Application Number: 2013/1383

**Conversion of integral garage into bedroom and erection of a double garage
5 High Street, Thurnscoe, Rotherham S63 0SU**

I enclose three copies of an amended plan for the above application showing an amended position for the proposed double garage.

SITE PLAN 1/200

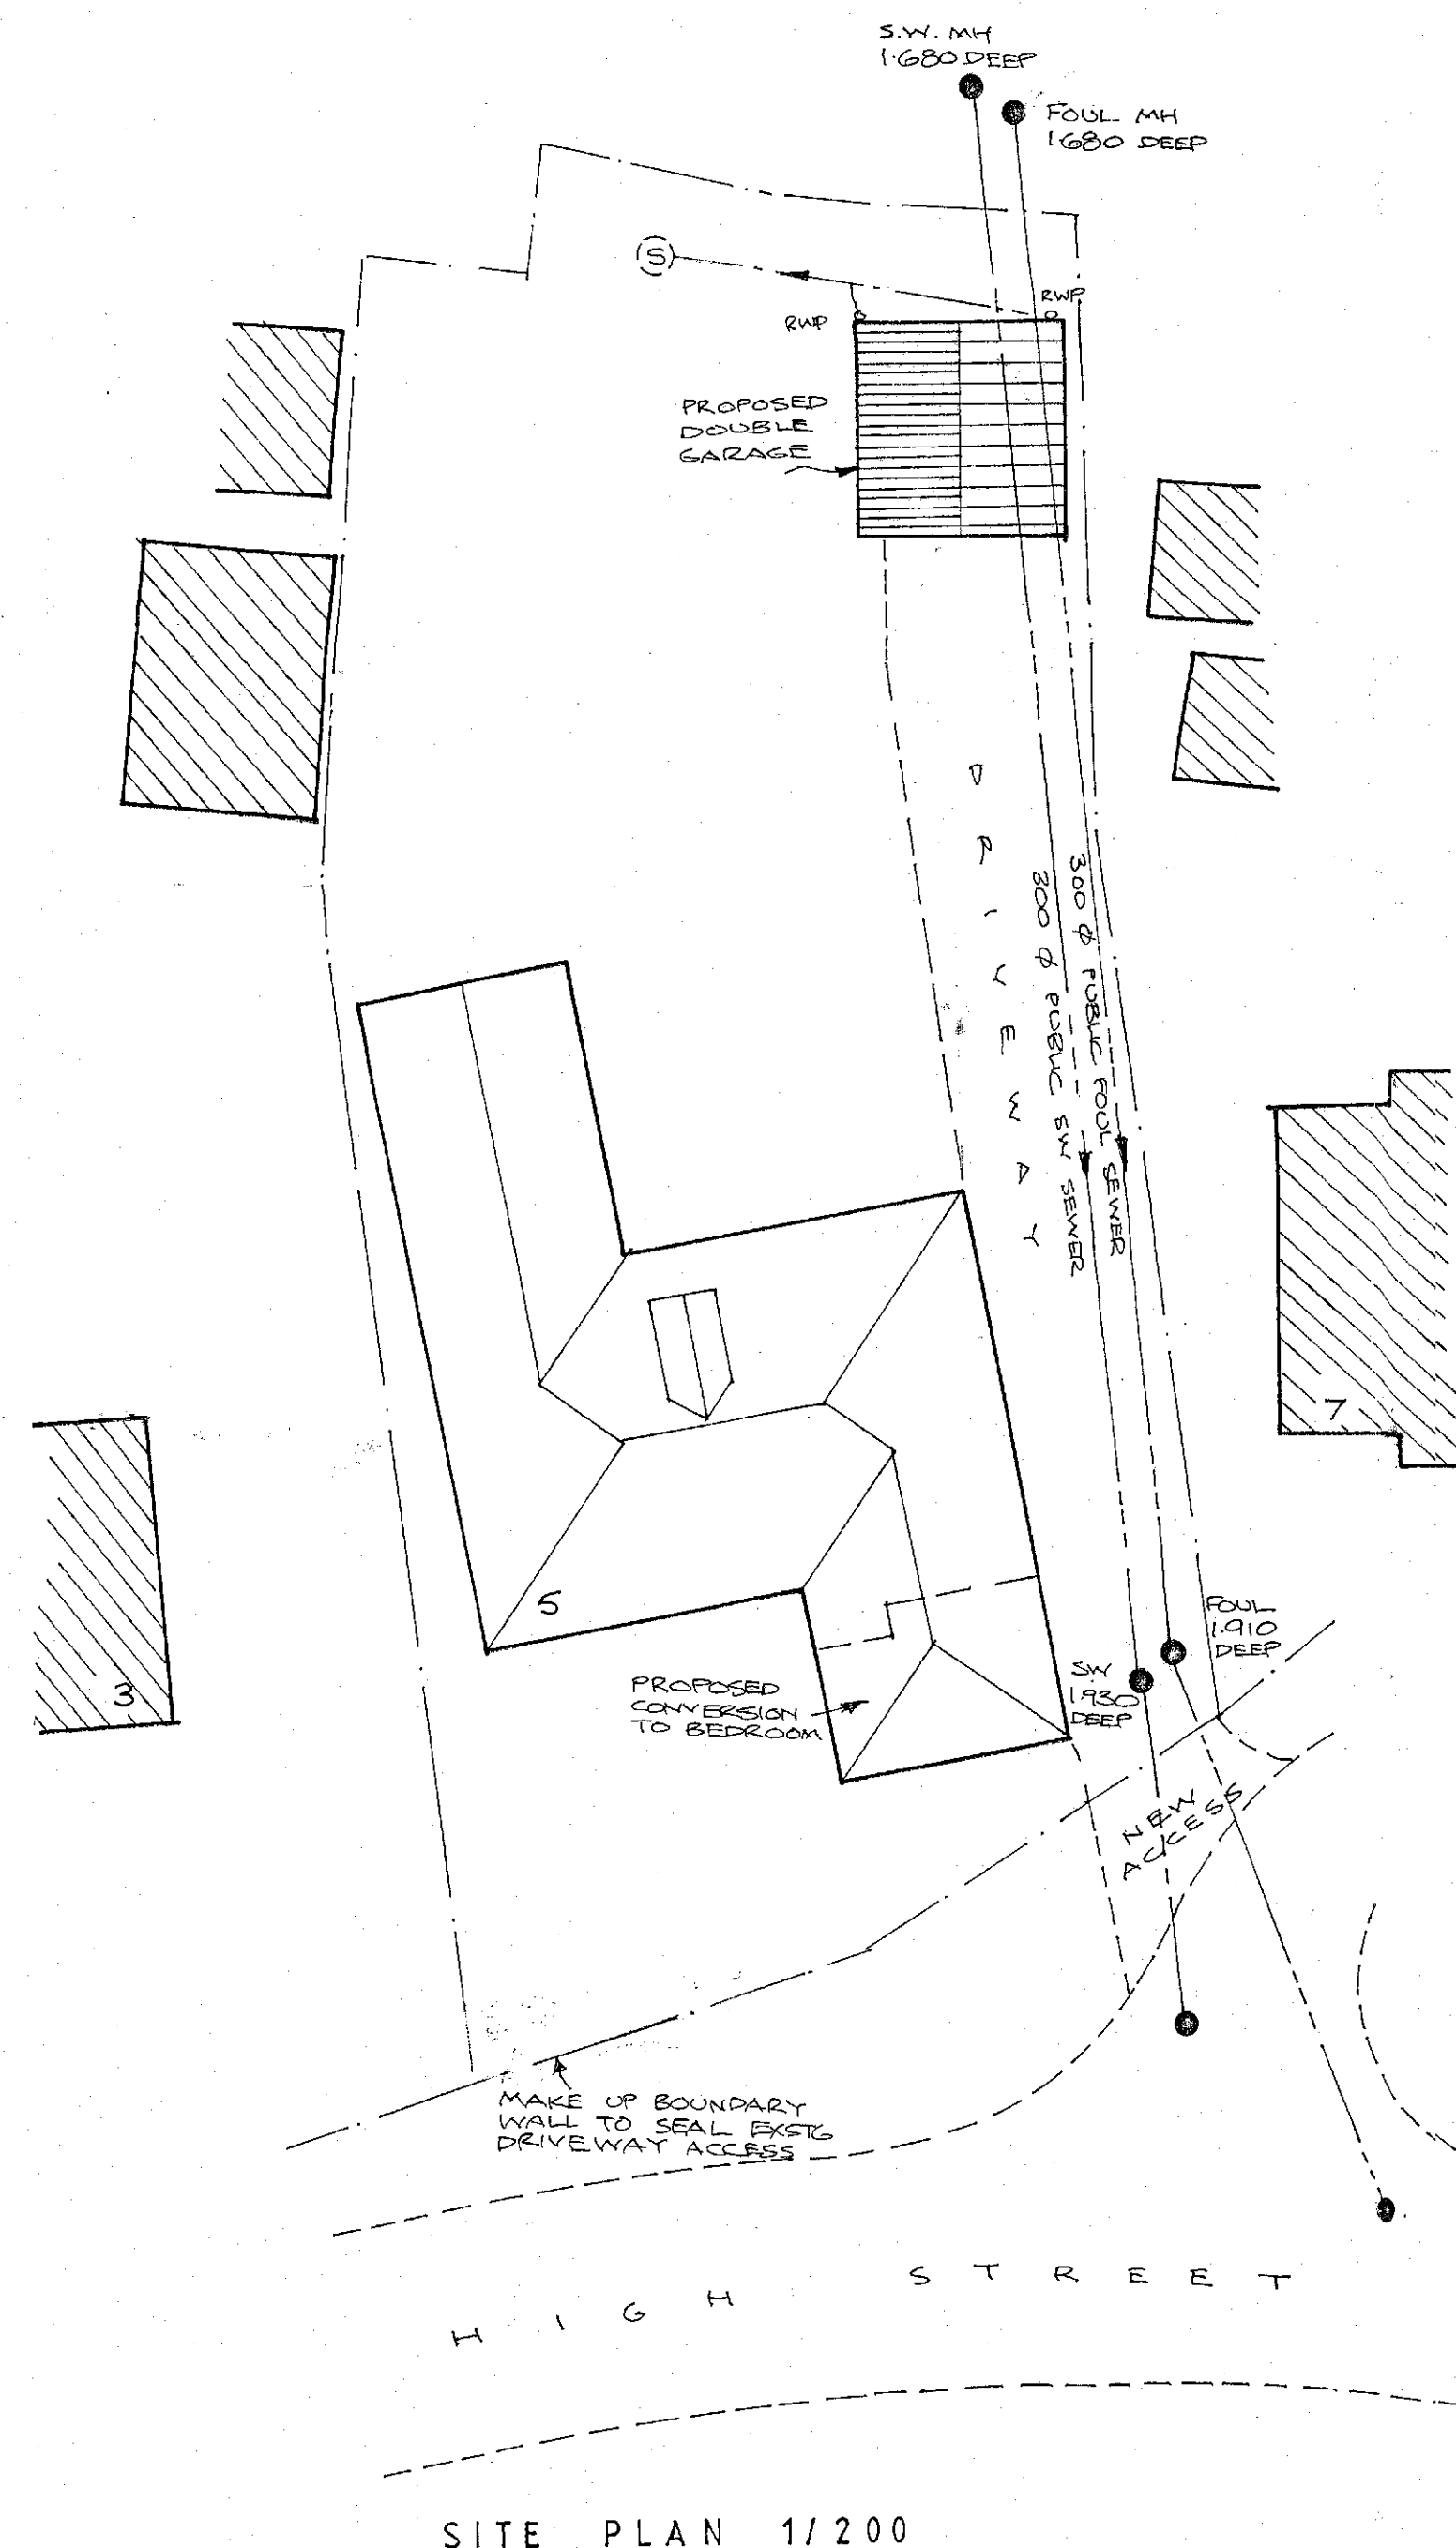
This amendment has been necessary as Yorkshire Water have refused permission to allow me to "build over" the two public sewers crossing the site, for the reasons shown on the attached letter from them dated 13th January, 2014.

The size of the double garage will remain the same, and so I trust this plan can be regarded as an amendment to my existing application, which has not yet been determined
